Online Comment

Application H16-1046-23
Location 4 SPRING GARDENS SPALDING PE11 2XL
Proposal Proposed annexe

Name Jim Bonnor
Address Historic Places Team Lincolnshire County Council

SHEET TITLE
PROPOSED PLANS & ELEVATIONS

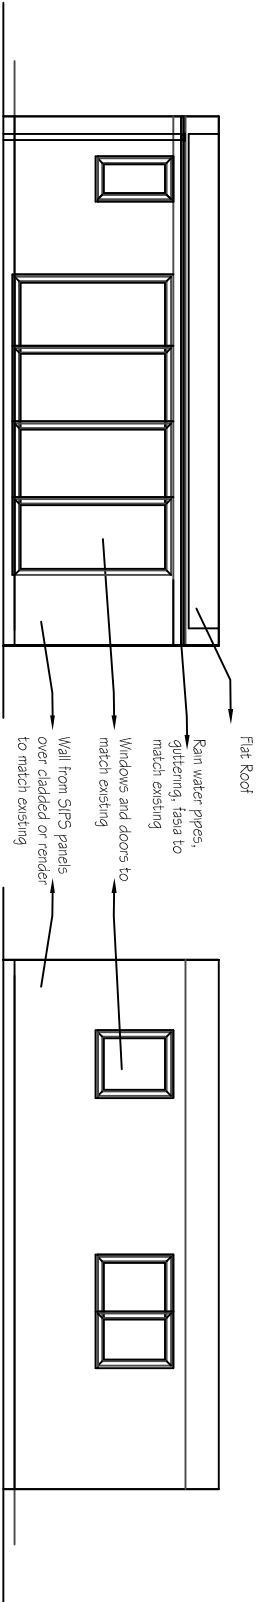
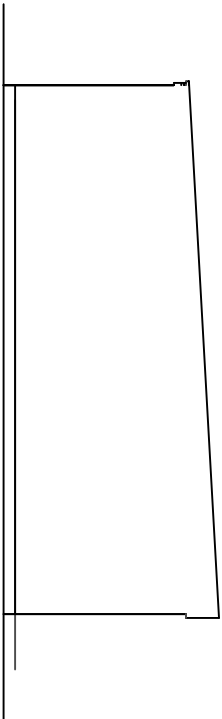
This is a relatively small development, though it is situated within the grounds of the medieval priory of St. Mary, founded AD 1052 and dissolved in AD 1540. The extents of the priory and location of some of its major buildings are known from historic mapping. Archaeological monitoring of building foundations in the vicinity has revealed evidence of medieval activity. This development, therefore, has the potential to impact significant archaeological remains.

It is recommended that the developer should be required to commission a Scheme of Archaeological Works (on the lines of 4.10.4 in the archaeological handbook). This should be secured by standard conditions AR01-03. The purpose is to ensure that any archaeological remains within the site are recorded prior to their destruction.

Initially I envisage that this would involve monitoring of all groundwork's, with the ability to stop and fully record archaeological features.
